Consultation Response from: KC Environmental Health (Pollution & Noise Control)
2023/91405 Part of former St Luke's Hospital site, Blackmoorfoot Road, Crosland Moor, Huddersfield, HD4 5RA
Erection of foodstore (class E) with associated access, parking, servicing area and landscaping
Responding Date:
14th June 2023
Responding Officers:
RM, NH, SR, MN
Responding Ref:
WK202315680

**Appendix 2
Proposed Layout Plan and Boundary Treatment**

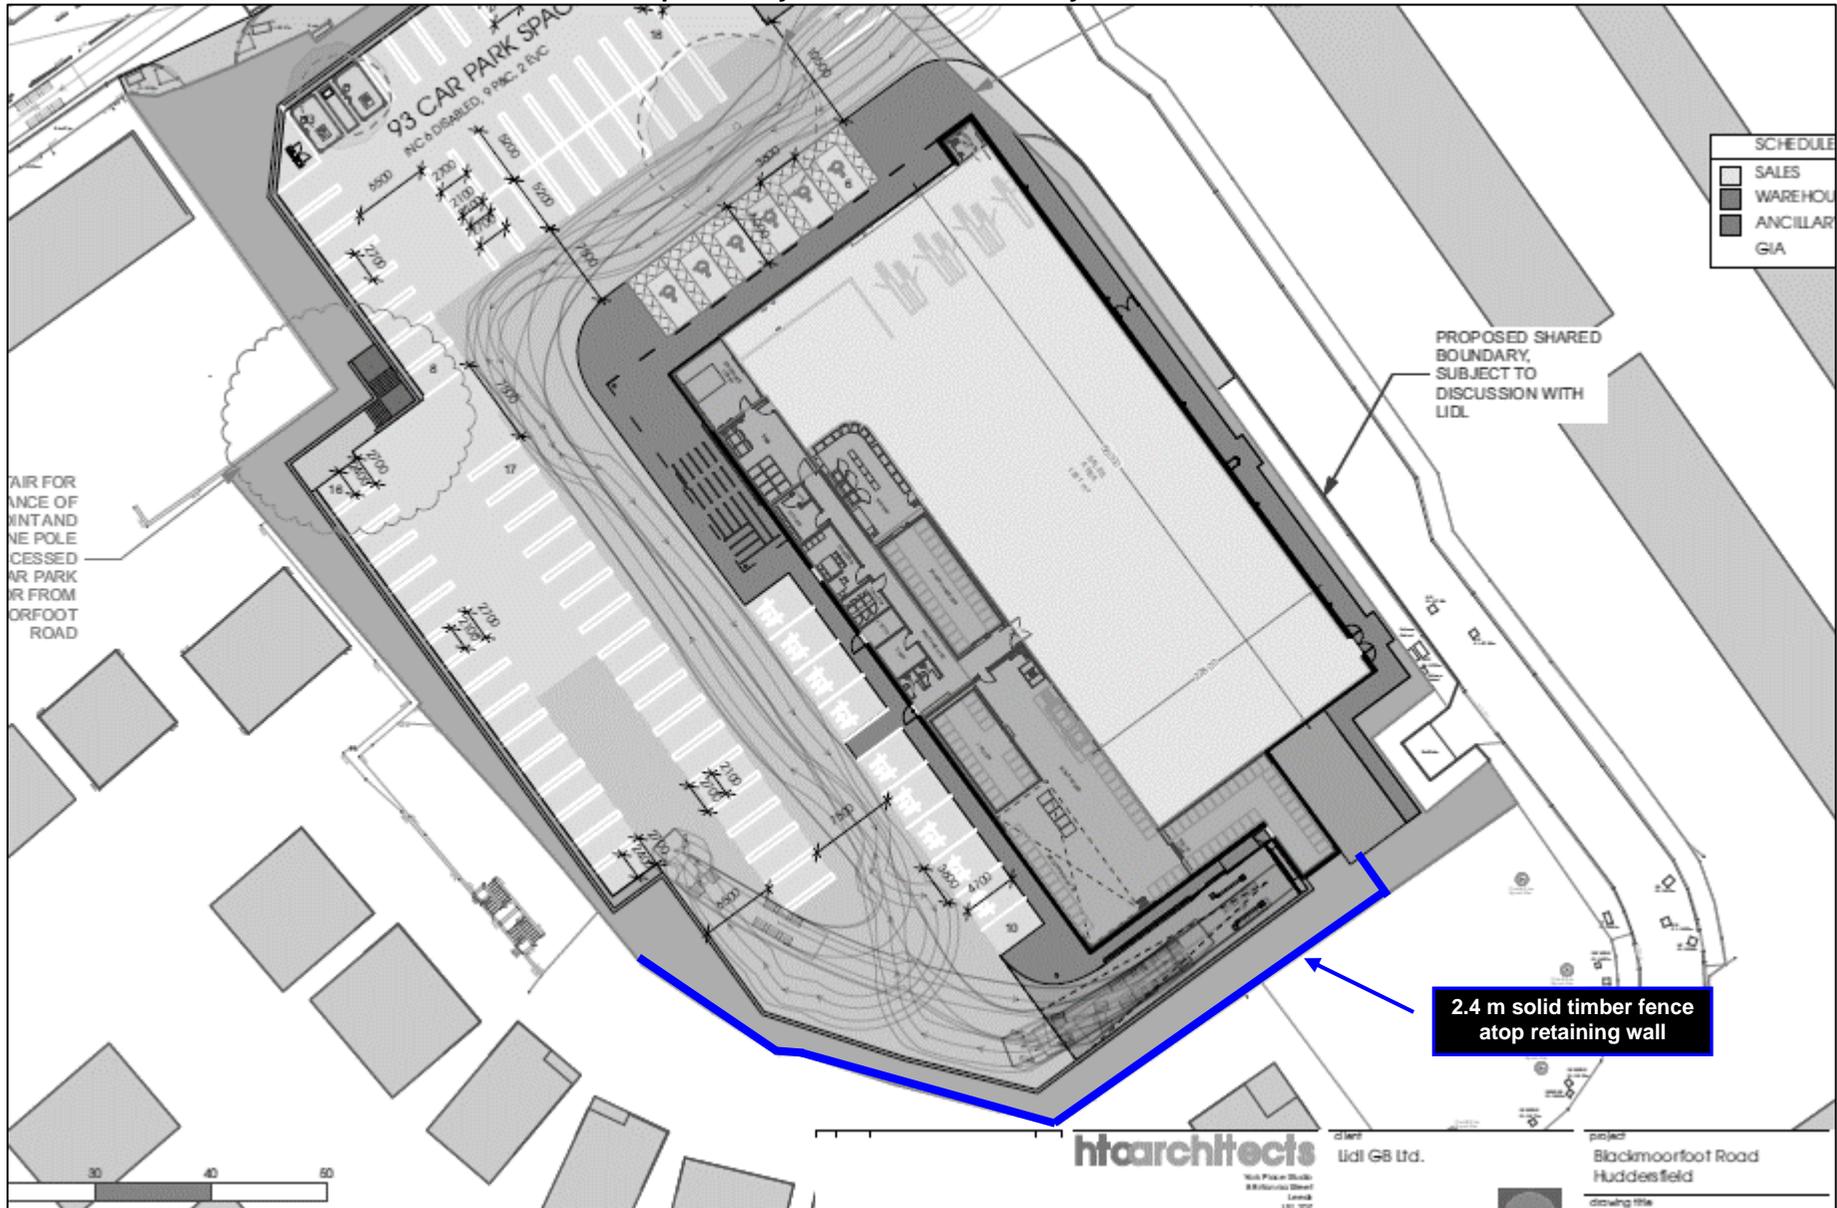
Based upon the delivery hours referred to in Condition 12, a recommendation is made for a 2.4m high fence to be installed along the southern and south-western boundary of the loading bay as shown in Appendix 2 and a spec is given. However, no reference is made to any predicted delivery noise, particularly during the sensitive times of the day and so no reference is made to the level of mitigation required. A condition is recommended for an additional/addendum report to be submitted to cover this aspect of the operational use. Should a fence be required in mitigation, a specification of the fence and installation will be required as follows -

- A plan showing the location of the barrier
- The minimum height of the barrier relative to the adjacent ground level
- The construction specification of the barrier including the barrier support structure, the barrier material, the minimum barrier thickness, the minimum density of the barrier material and the details where the barrier meets the ground.

Rev	DSR no.	Comment	Date	LiAS	KAM	Project Number	Project Name
0	D-472482	Initial proposal.	02/09/22	MD	RF	0400667192	Lidl St Luke's Hospital Huddersfield
						Scale & Sheet Size NTS @ A3	Drawing Name LiAS DESIGN NOTES & LUMINAIRE SCHEDULE
						Sheet No DWG 00

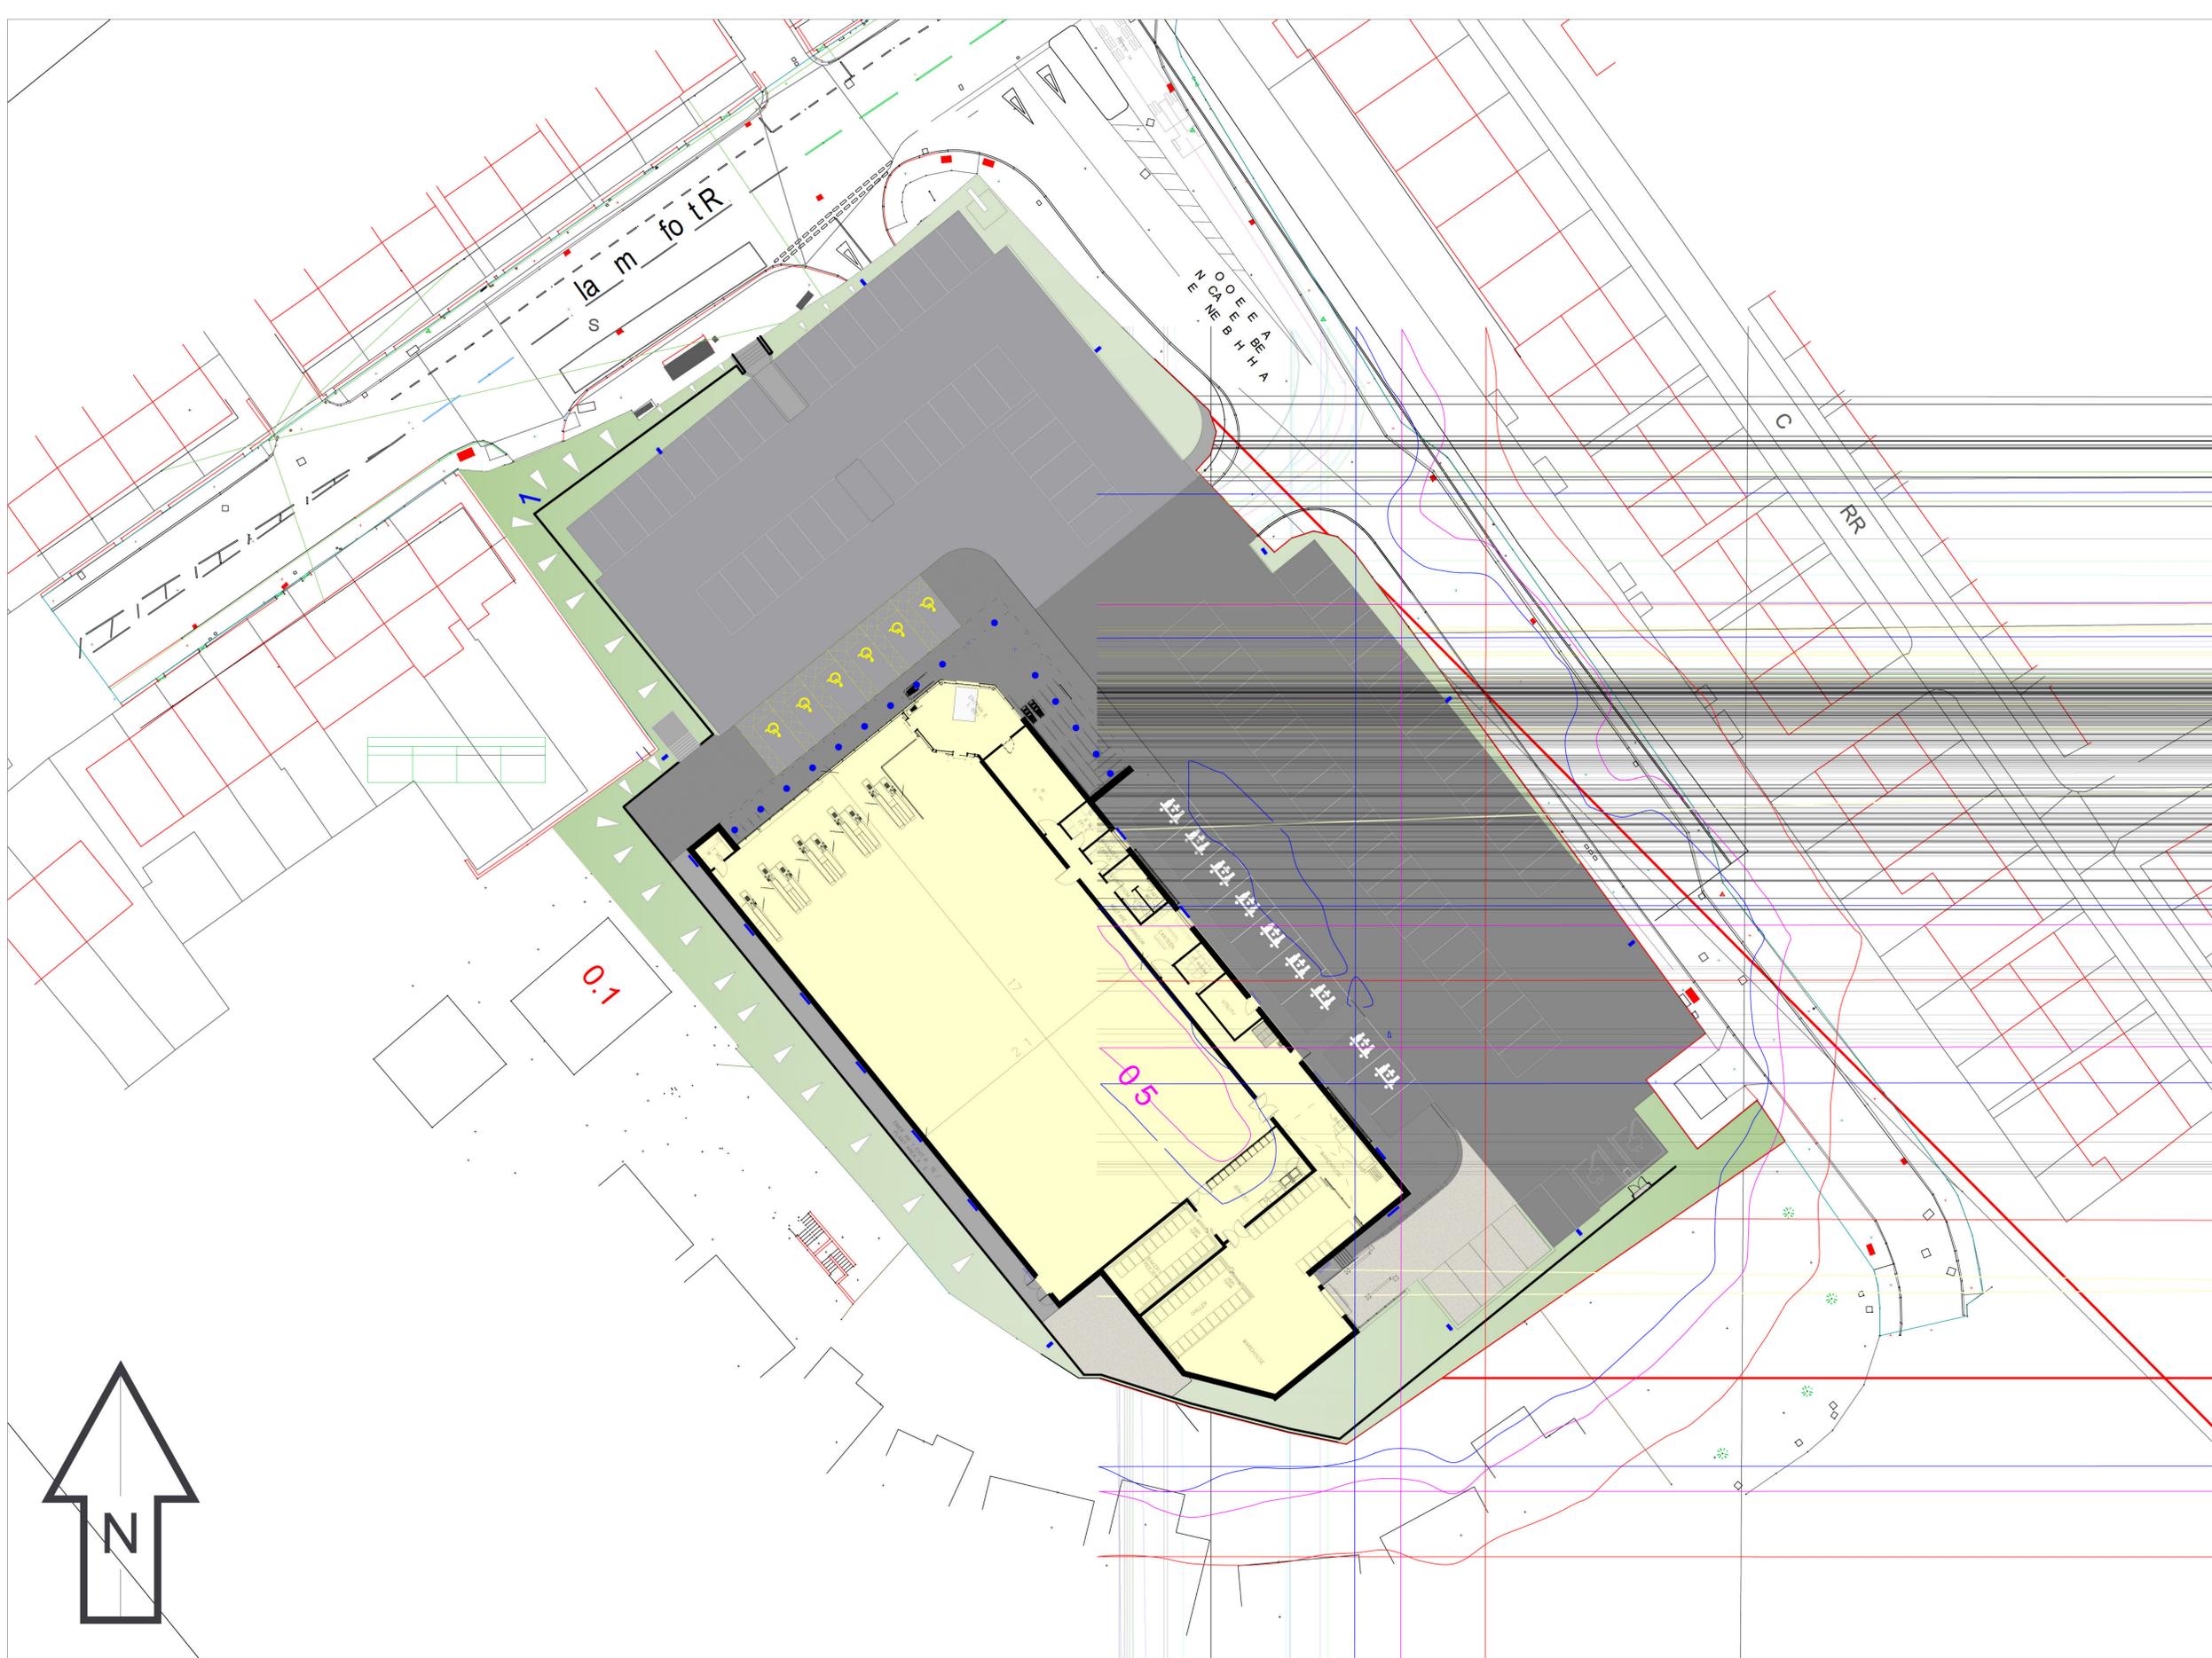
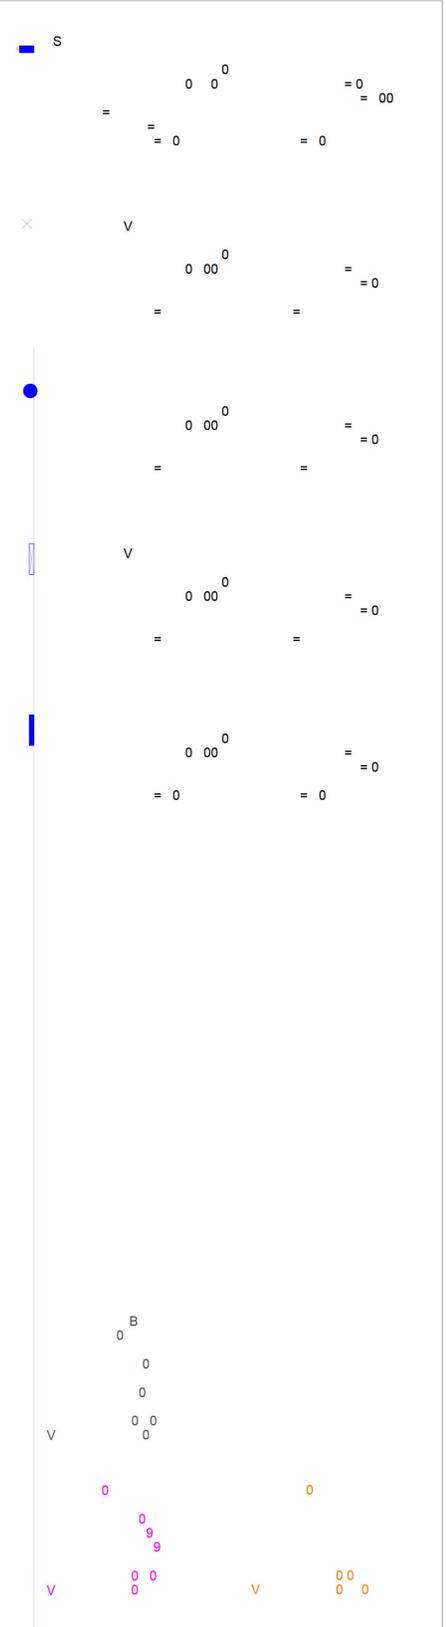
The Lighting Layout plan demonstrates light spill into gardens of nearby residential properties. The wall mounted light fittings LL-E mounted at 3.25m could be directly in line with existing rear windows, light spill is shown into gardens from these fittings. The LL-C fittings are mounted at 6m, light spill is shown into gardens from these fittings and direct glare could also result from direct line of view to the luminaire.

The Lighting Layout Plan mentions assumptions about the project and therefore we cannot confidently accept the information as it may be subject to change.
